**From:** Frances Stevenson [REDACTED]  
**Sent:** 28 September 2026 11:34  
**To:** Botley West Solar Farm  
**Subject:** Botley West Solar Farm: Community Food Growing

### Botley West Solar Farm: Community Food Growing

In response to your letter of 4 September 2026 giving Interested Parties the opportunity to comment on the Applicant's most recent submissions, I am writing regarding the Applicant's proposal for community food growing on 30 ha of land in Bladon, West Oxfordshire.

**Illustrative Masterplan**  
**Figure 2.2A**  
 Central Site Area 1 of 4

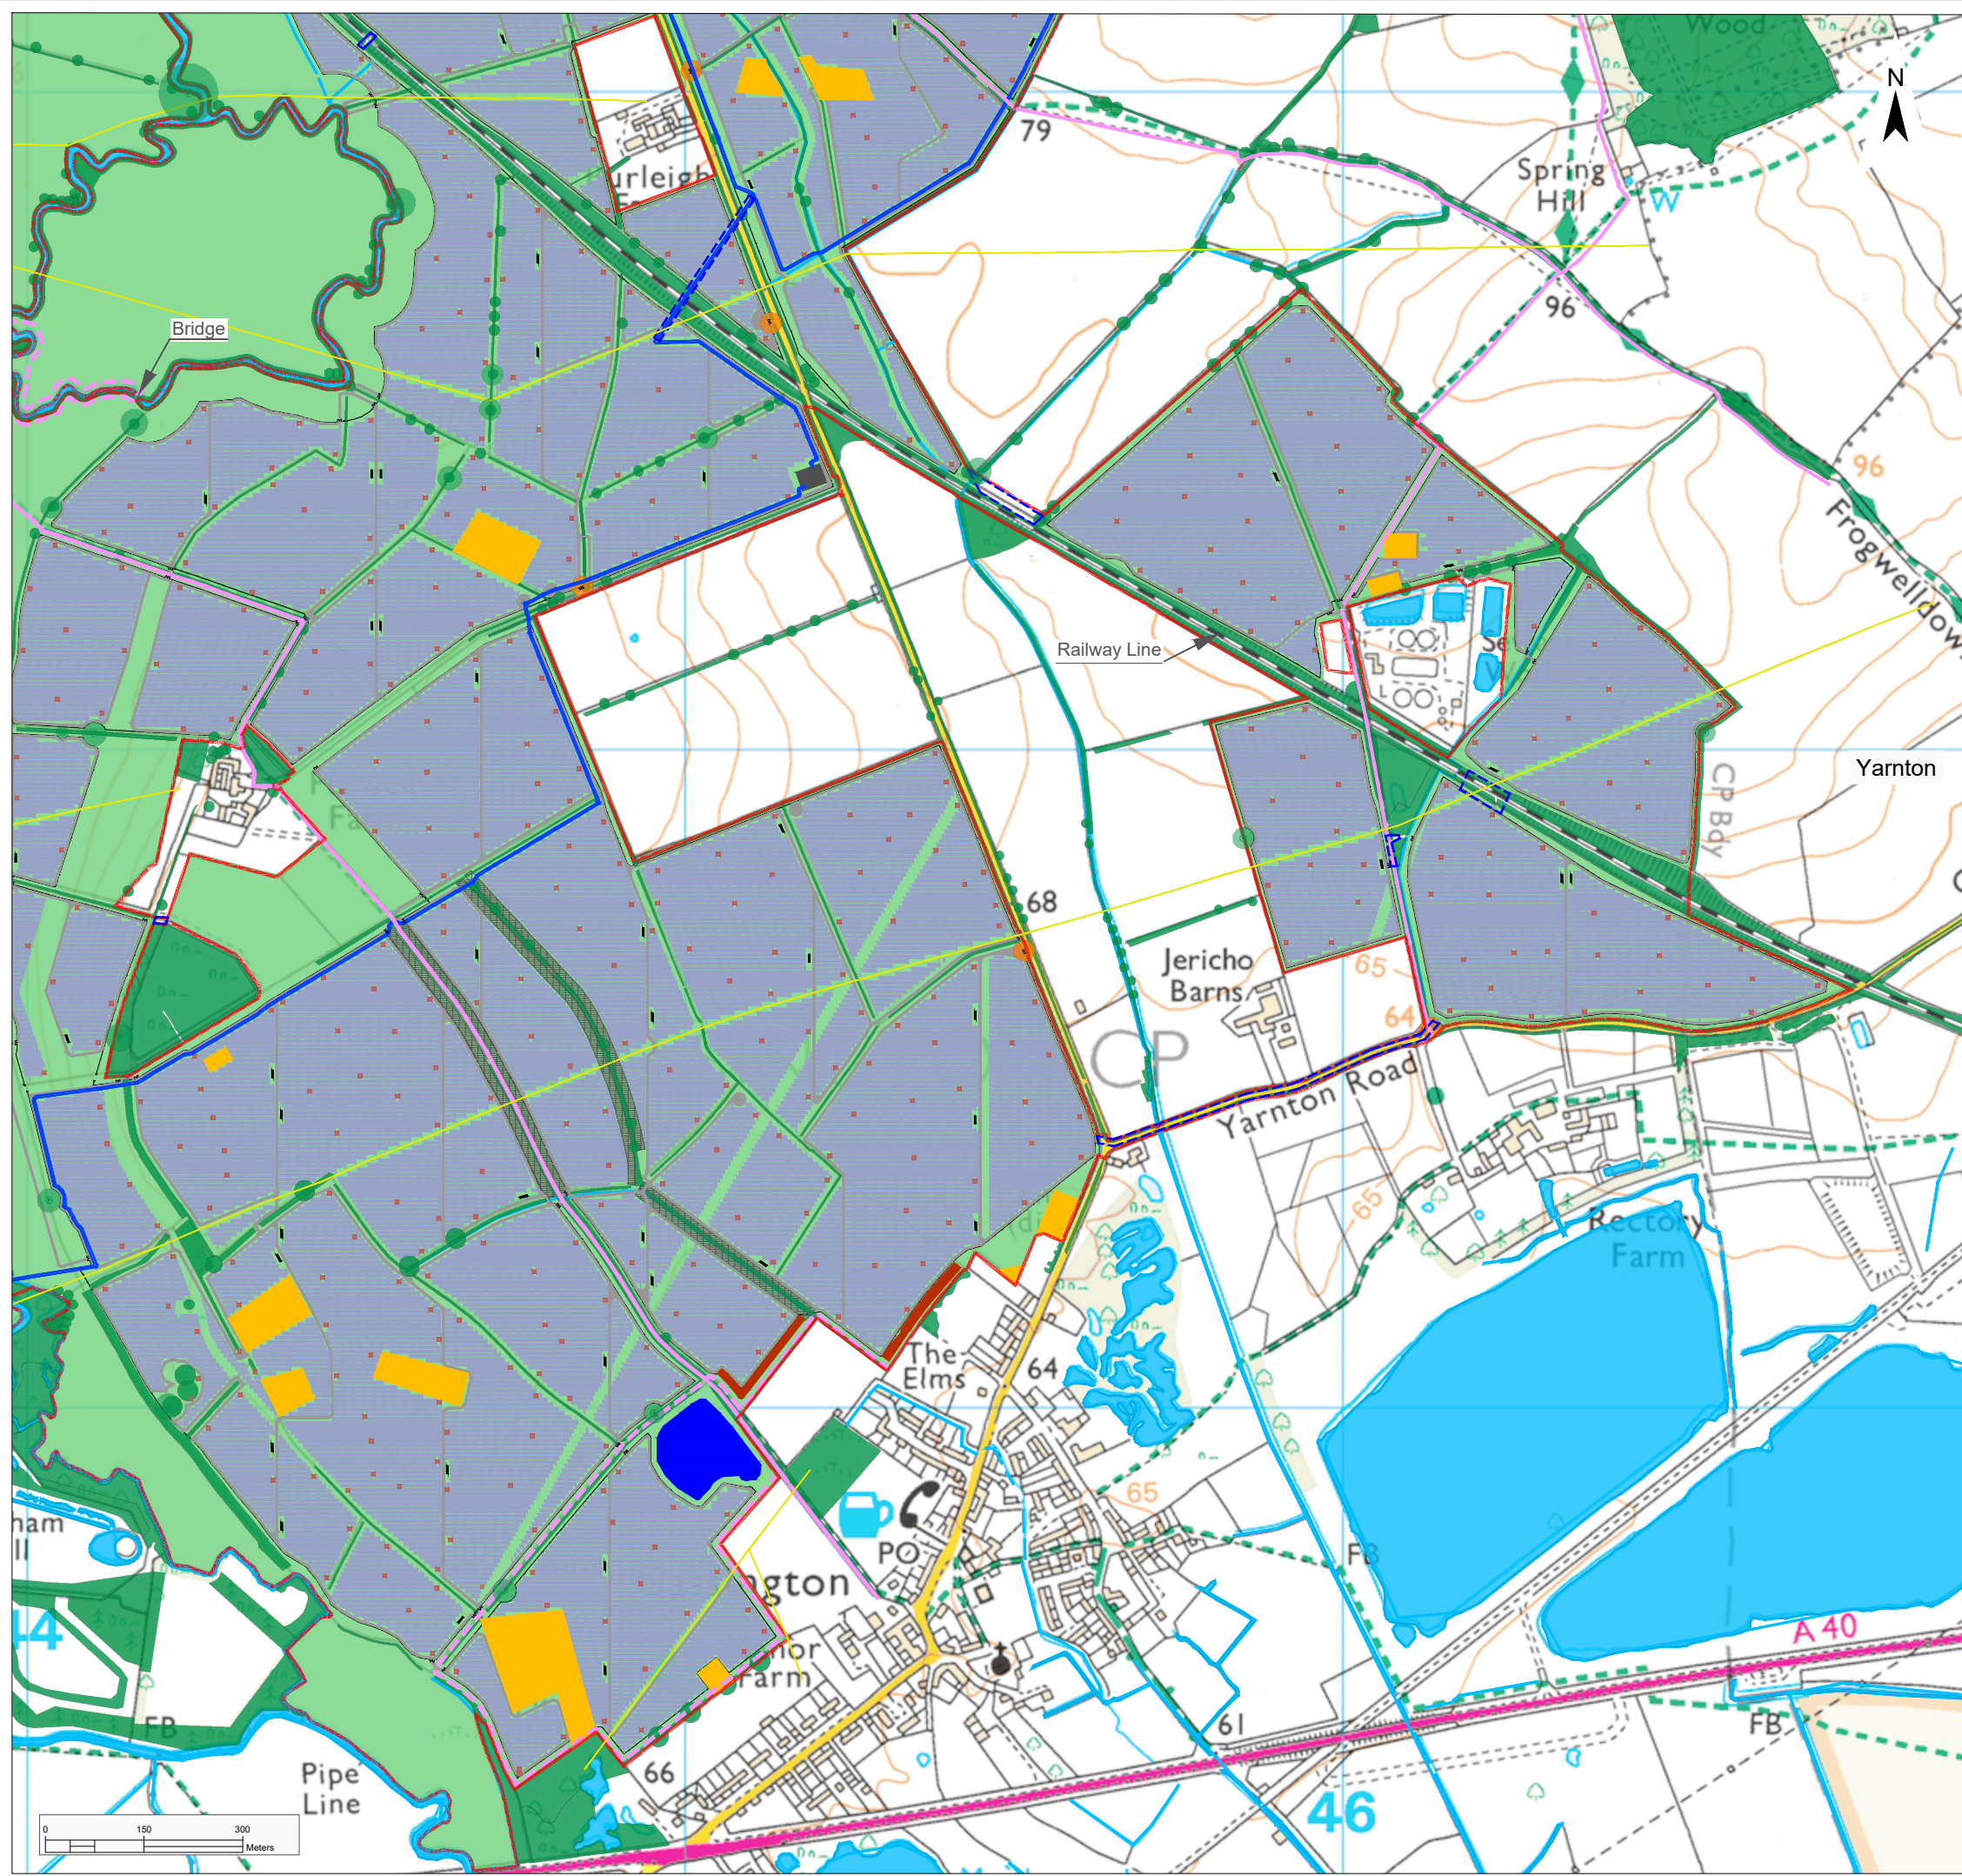
- Has not explained the interest in community food growing adequately or correctly.
- Has not explained how suitable access will be provided for the proposed food growing site in Bladon.
- Has not explained how the proposed food growing site in Bladon would be protected from inappropriate structures or how compliance would be guaranteed. (This is especially concerning because the site lies in the setting of the Blenheim World Heritage Site within sight of the Palace and grounds.)

I would also like to mention that the Applicant's Illustrative Masterplan (C1118 - Response to Secretary of State Consultation 1 - 6.4 ES - Figures 2.1a - 2.4c - Illustrative Masterplan - Rev 5) does not enable Interested Parties to distinguish between 'New planting/areas for enhancement' and 'Land available for community food growing area' because of the choice of colours used. We cannot tell whether changes have been made or what they might be.
